Nelson Property
Mike Melanson
831-9311

Revision on Step Dimension
Property Address
Overhead Door company
533 Riverside Industrial
Parkway, Portland ME.
04103
Permit # 2016-02842

Permit # 2016-02842

TOP view

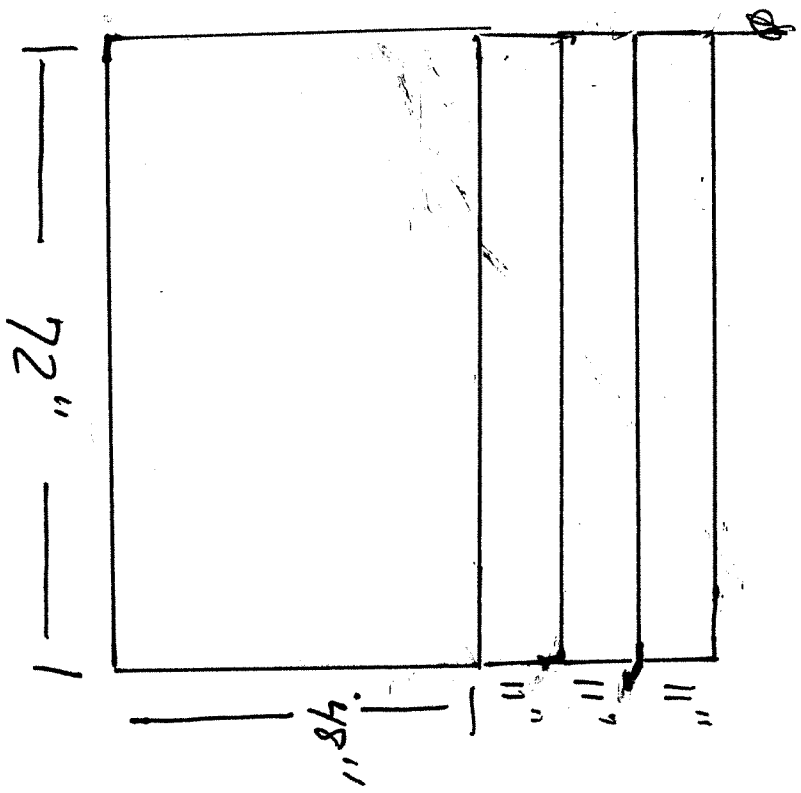
Box Down
12" Indes
Compact New Gravel
1" and then
pave over

POURED concrete with
Rebar REINFORCEMENT
and wire mesh if needed.

Hand Rails will be
made to meet code.
